Please ask for: Nicola Moore
Email: nicola.moore@arun.gov.uk
Telephone: Ext 37944
Our Ref: A/130/21/PL
Your Ref:
Date: 21st June 2021

Application for Planning Permission

Development: Demolition of existing garage, conversion of existing dwelling to 2 No. 2 bed dwellings, single storey side extension, provision of 4 parking spaces and cycle/refuse storage. This application is within CIL Zone 2 and is CIL liable as new dwelling.

Location: 16 Pine Trees Close Angmering BN16 4LT

DRAWING NO	DATE	DRAWING	PROJECT
1485-01	25.02.21	SITE LOCATION AND BLOCK PLAN	16 PINE TREES CLOSE ANGERING LITTLEHAMPTON BN16 4LT
DRAWN	SCALE		
RC	AS SHOWN @ A1

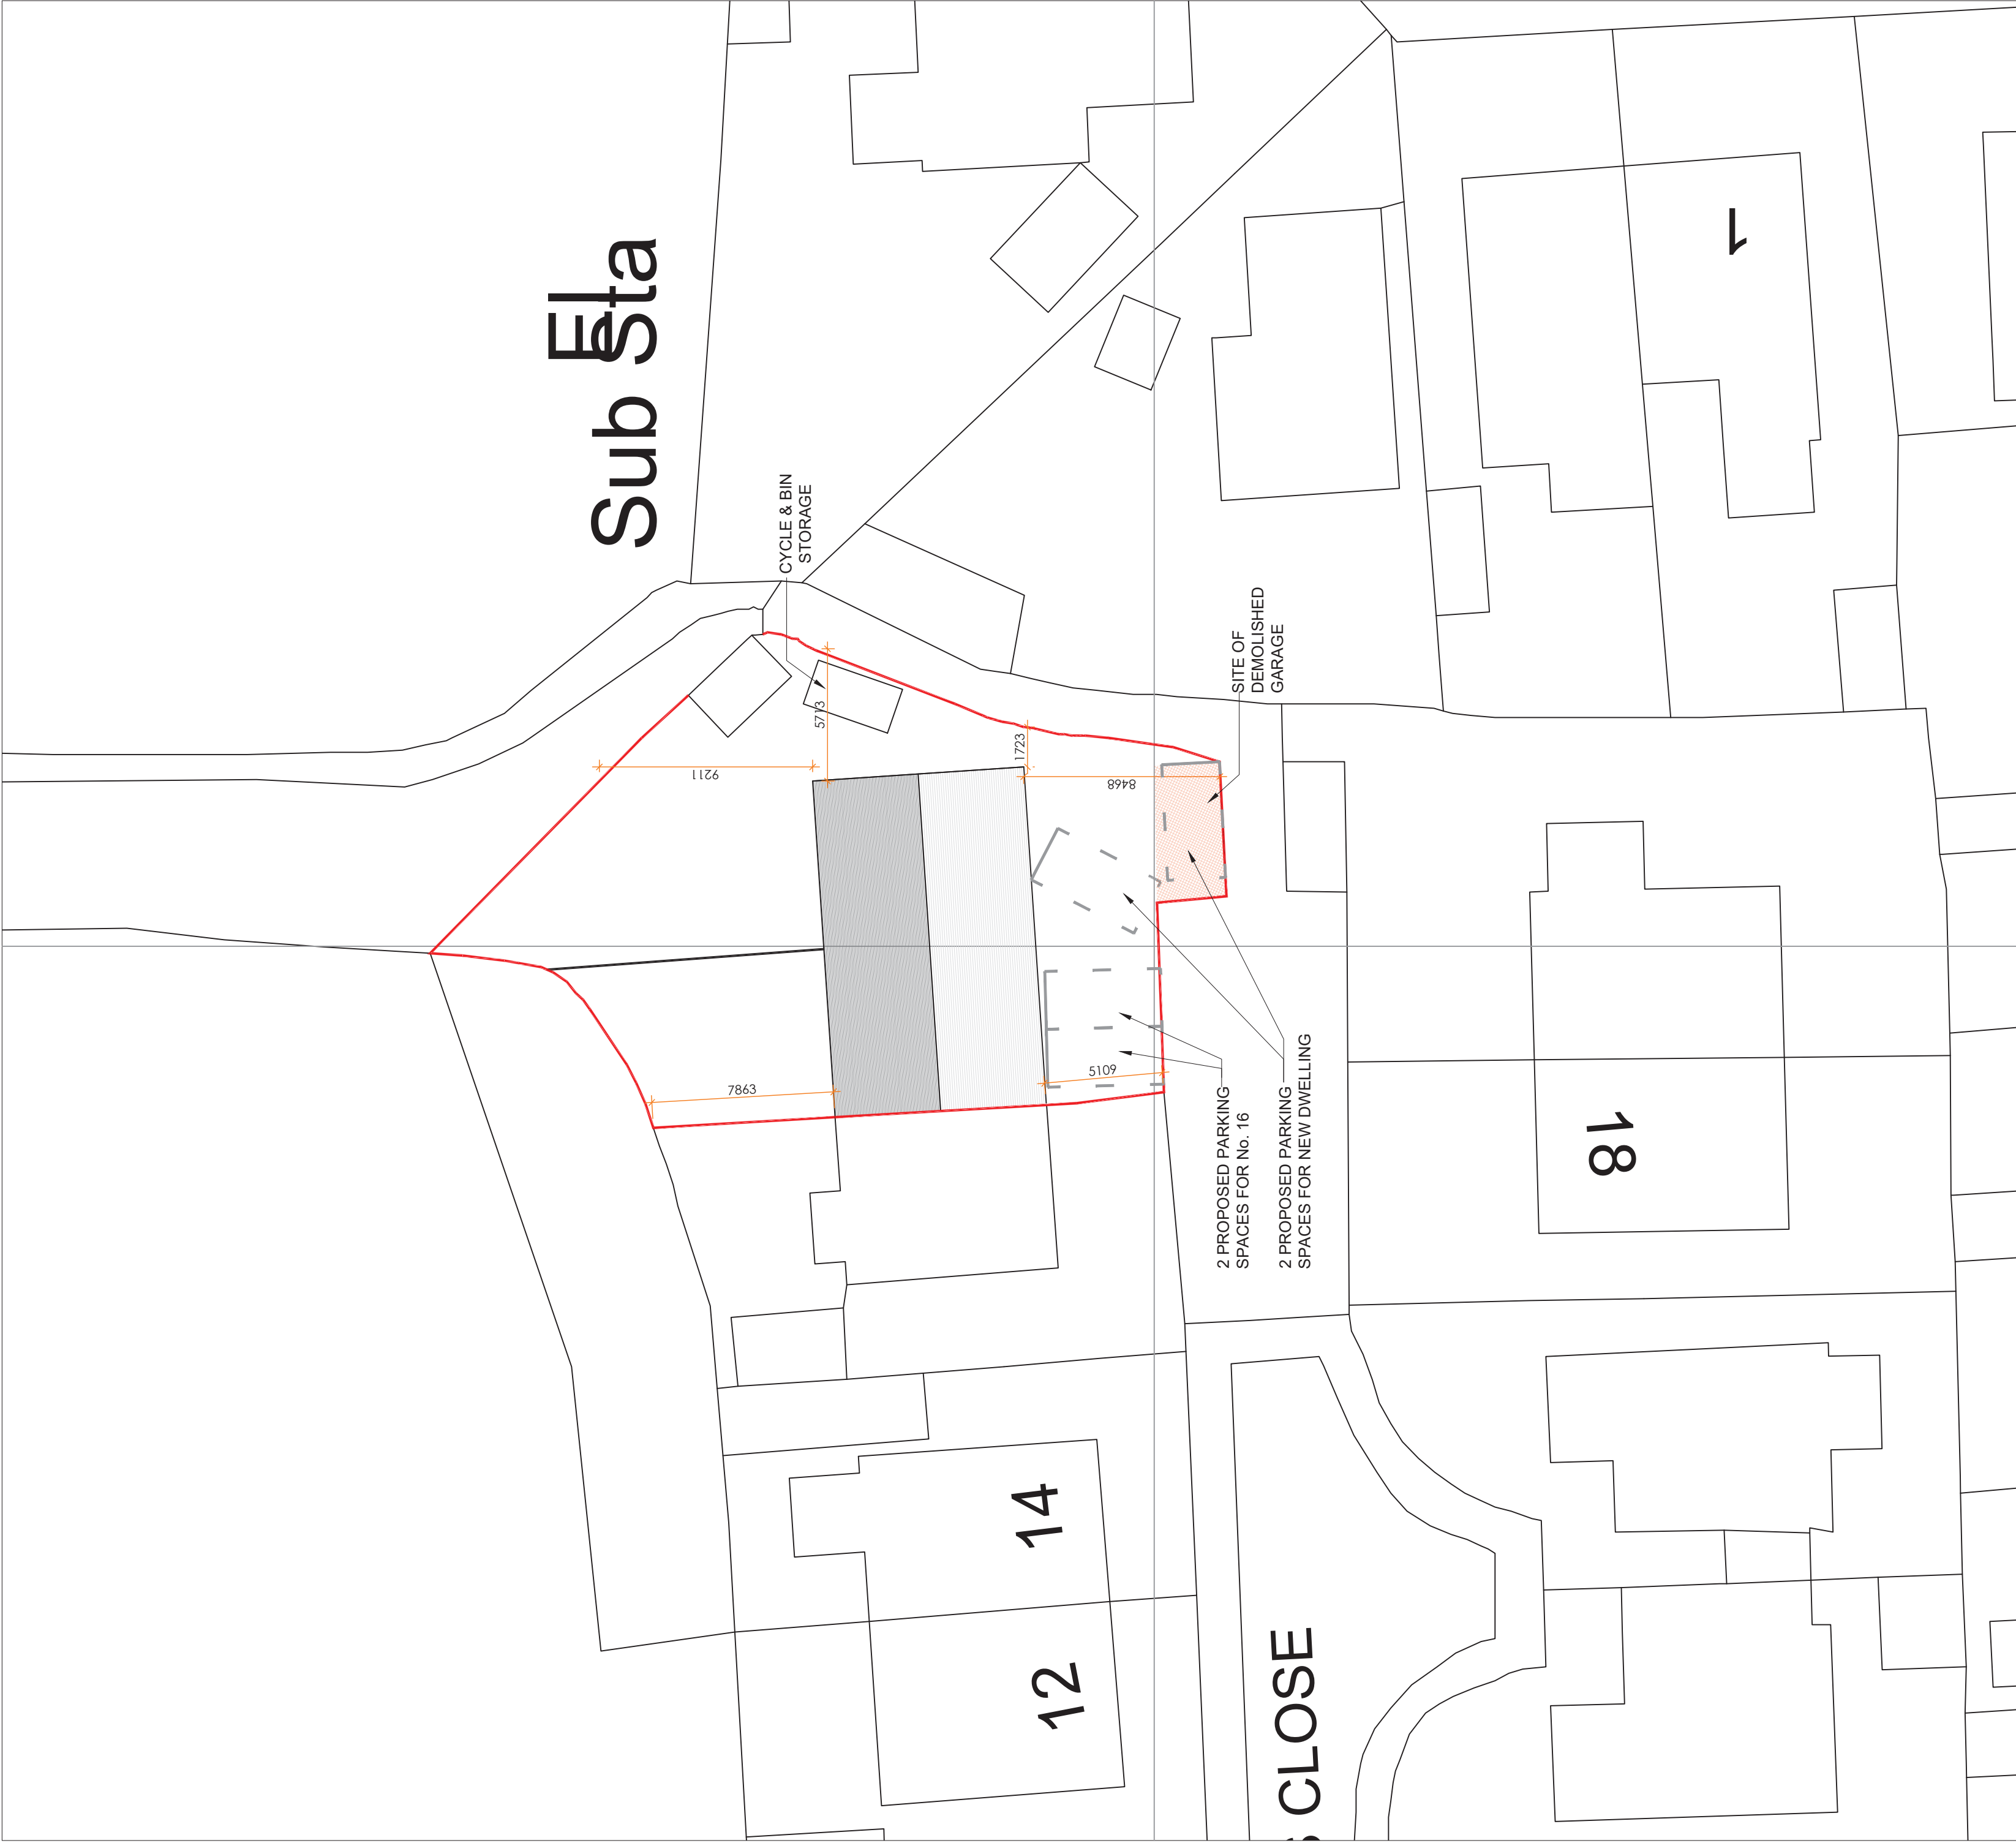
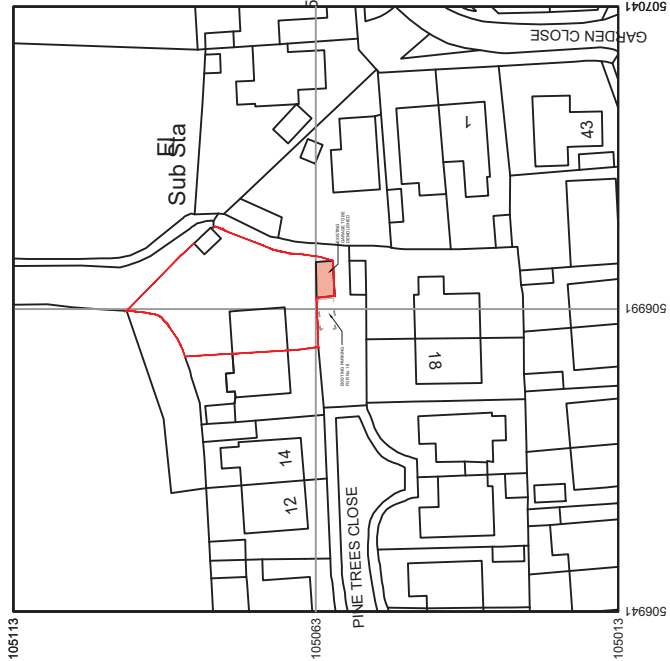
Block Plan

Please amend the Block plan to include dimensions to boundaries and re submit.

The Proposed Site Plan should clearly show the area of the demolished garage. Please amend accordingly and re submit.

For clarity, please confirm what the hatched rectangle at the south boundary on the location plan is.

The Location Plan and Block plan red edges do not match as the location plan and site/location plan does not include the rectangle on the southern boundary. Please amend accordingly and resubmit.
